RE: GARDEN FRESH (G21-D35). DRAINAGE PLAN SUBMITTAL FOR BUILDING PERMIT APPROVAL. ENGINEER'S STAMP DATED JULY 23, 1997.

August 5, 1997

Based on the information provided on your July 25, 1997 submittal, City Hydrology has the following comments:

**GRADING & DRAINAGE PLAN**

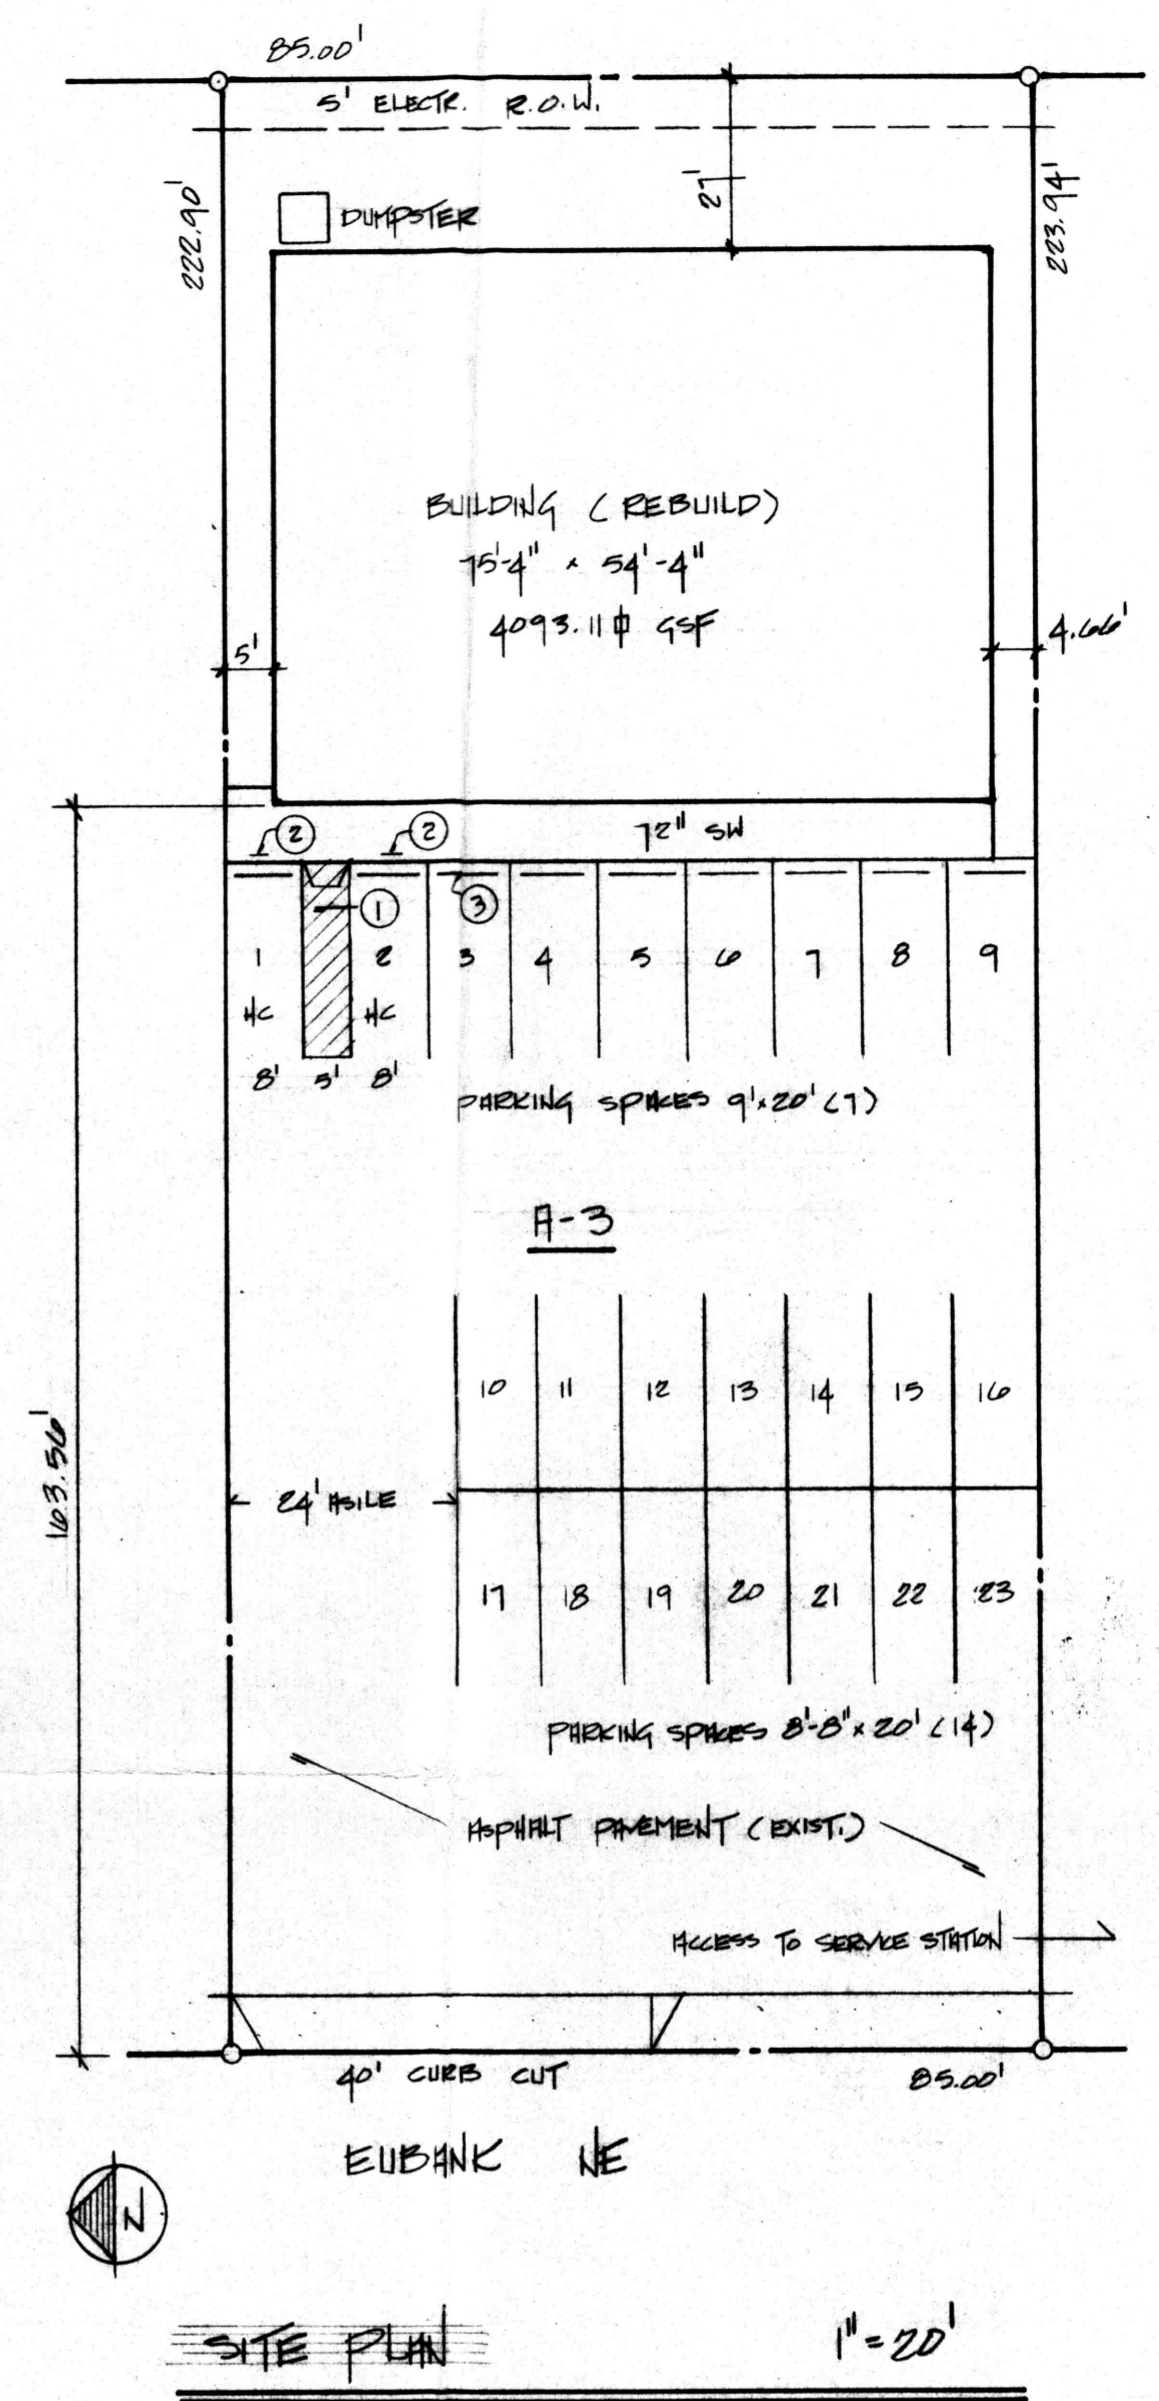
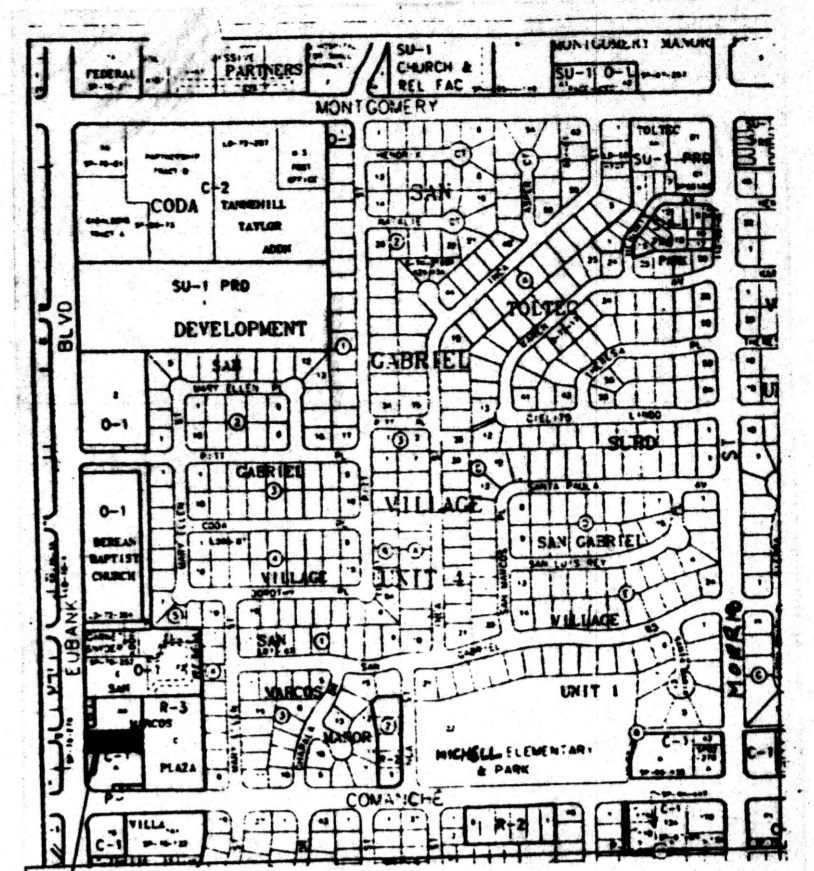
1. I vaguely recall discussing this site with you. You will need to submit some narrative explaining what you are proposing, what historic conditions are, discharge justifications, etc.
2. If you want to keep the swale in the same location, a sidewalk culvert will be necessary. Private storm water is not allowed to flow over the top of a public sidewalk. An SO #19 Permit will be required for a sidewalk culvert.
3. Provide some more proposed spot elevations.
